Preliminary Acceptance Punch List

Abert Ranch Final Plat

4-18-2024

Abert Ranch Final Plat (SF1911)
Jerome W. Hannigan and Associates, Inc.
19360 Spring Valley Road
Monument, Colorado 80132

**SETTLERS RANCH ROAD  
PLAN & PROFILE  
(STA: 46+00 TO STA: 58+00)**

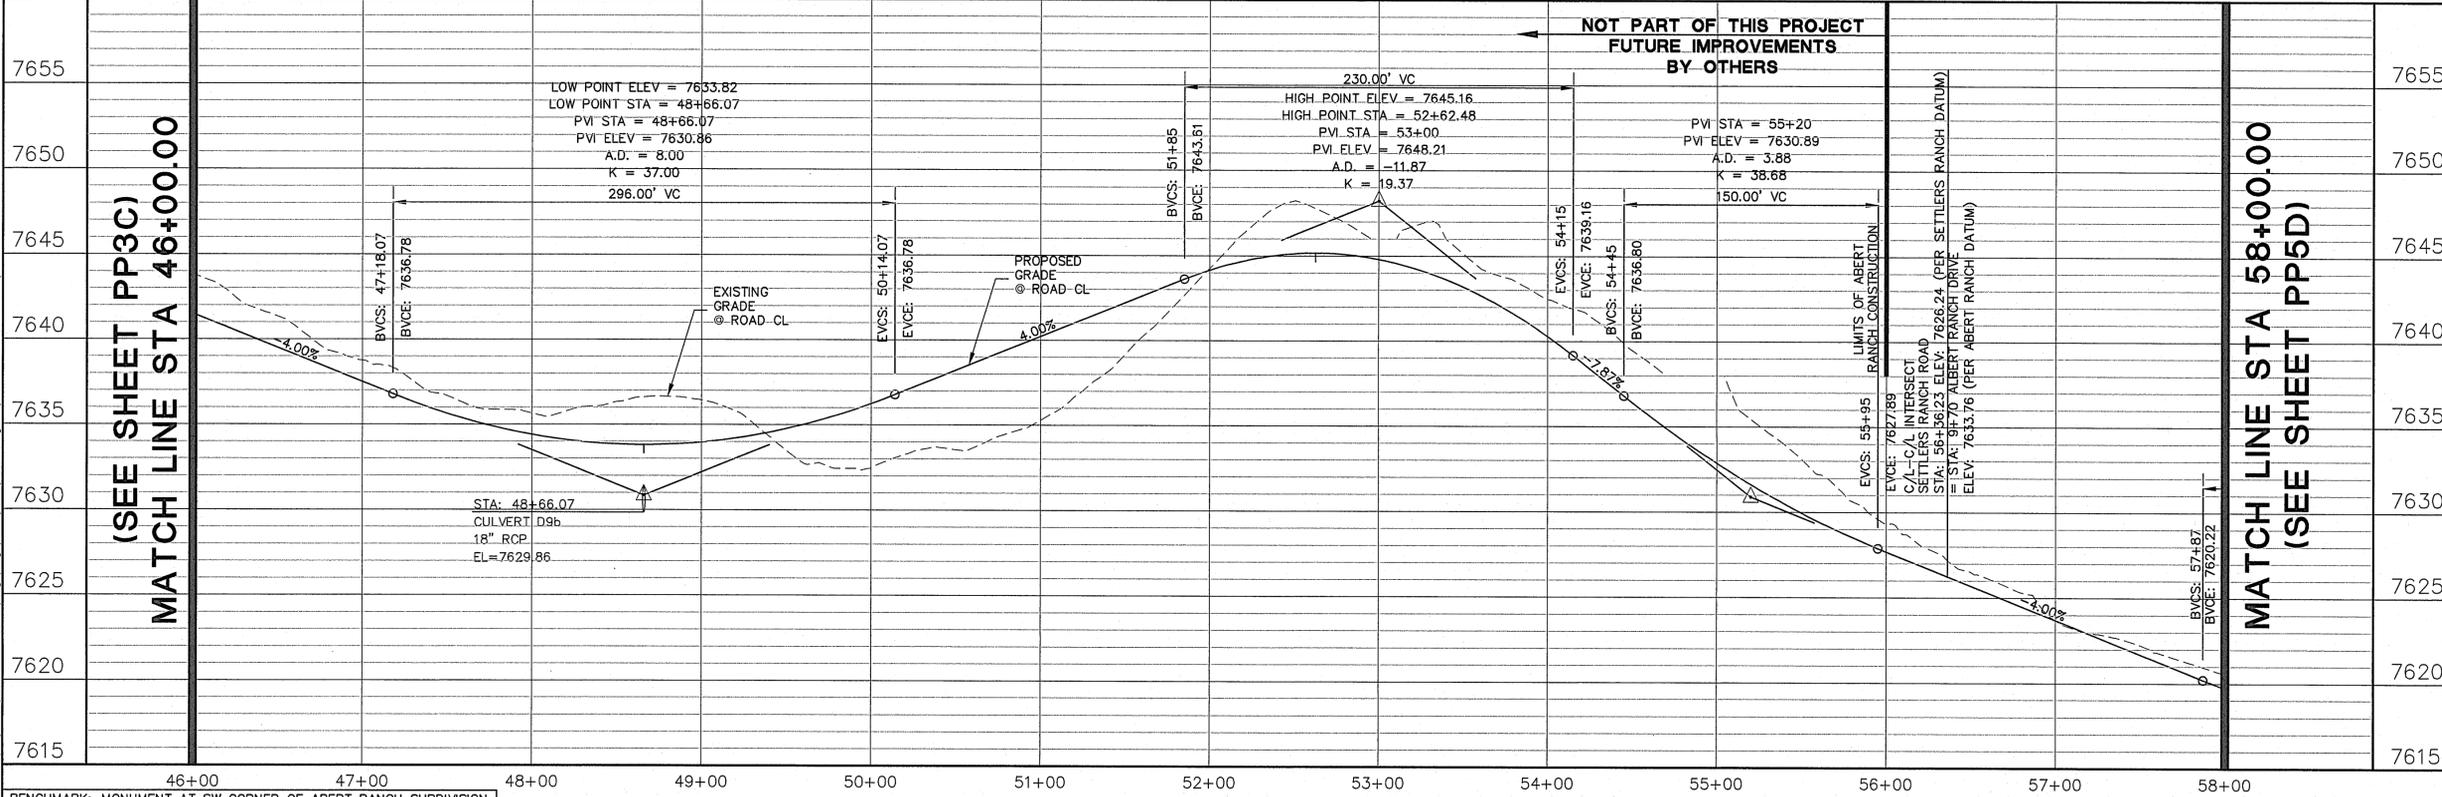
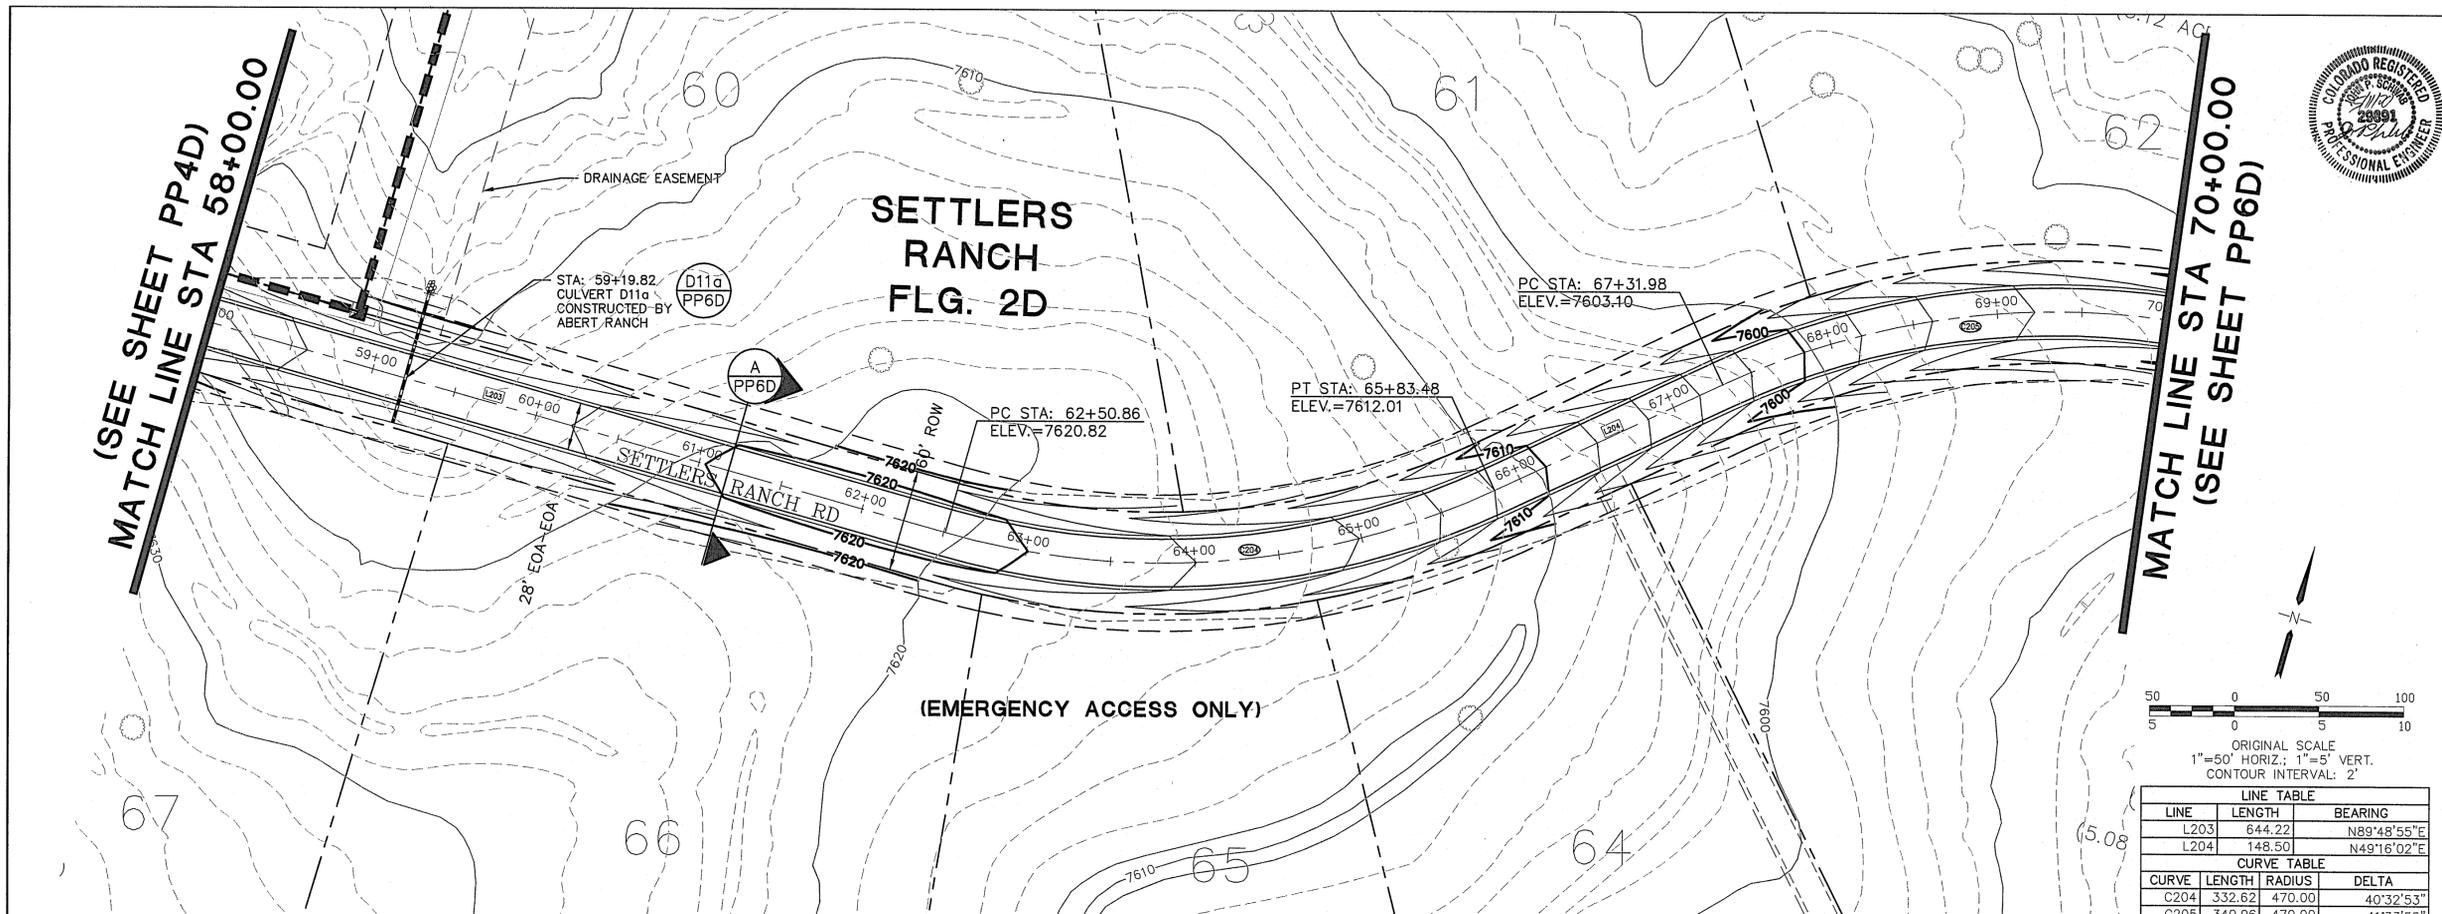
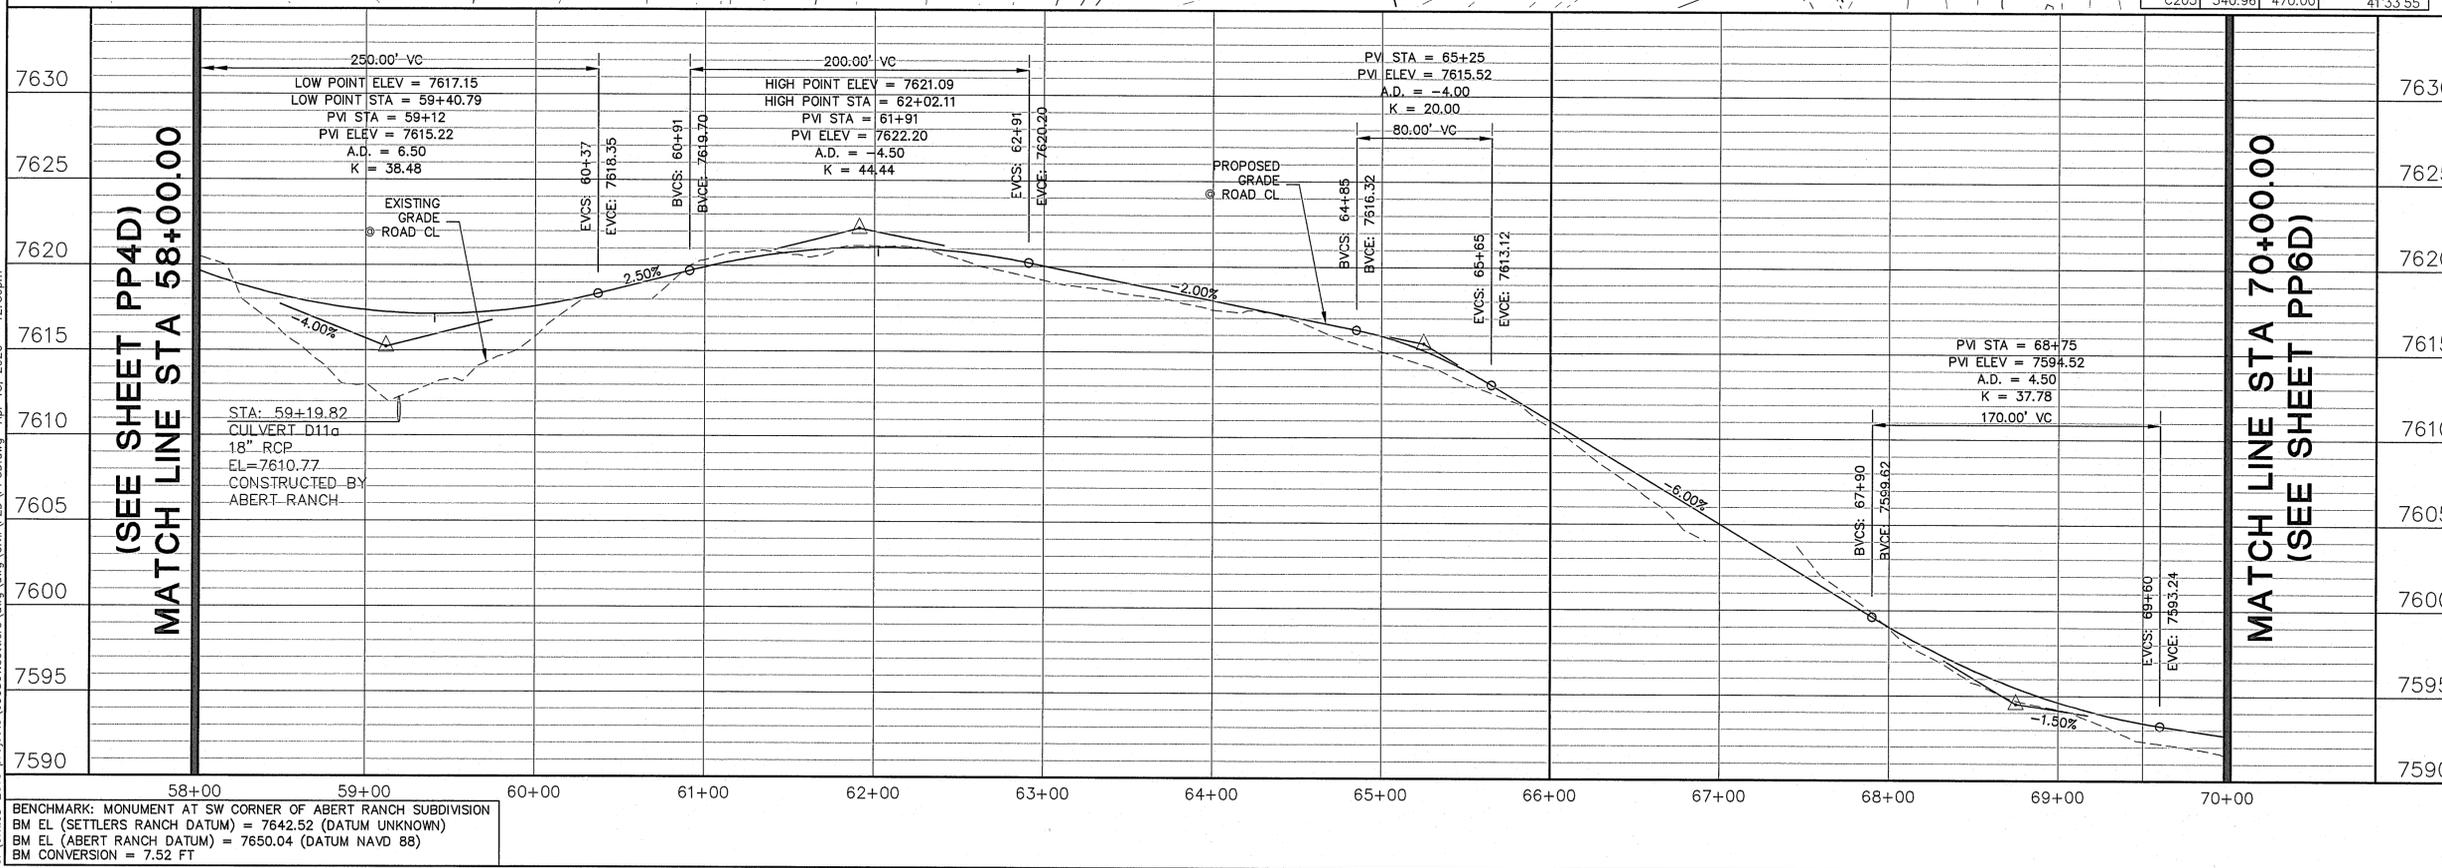
- Install missing restricted access bollards with chains found at the Abert Ranch Drive and Settlers Ranch Road (emergency access road) intersection.
- Install missing restricted access bollards with chains found at the Settlers Ranch Road and Stepler Road intersection.
- Correct the emergency access road to match the plans (found on page PP6D). The road should be 32’ with 12’ travel lanes on both sides and a 4’ shoulder. Also note that construction by Abert Ranch shall provide 6” ABC for future asphalt on this road.
- Asphalt patch (full width of road) for sinking at the culvert west of the cul-de-sac (west from 17326 Abert Ranch Road).
- General- Please ensure all shoulders of roads are installed and graded to speck according to plans. Some areas seem to have washed out from storms.
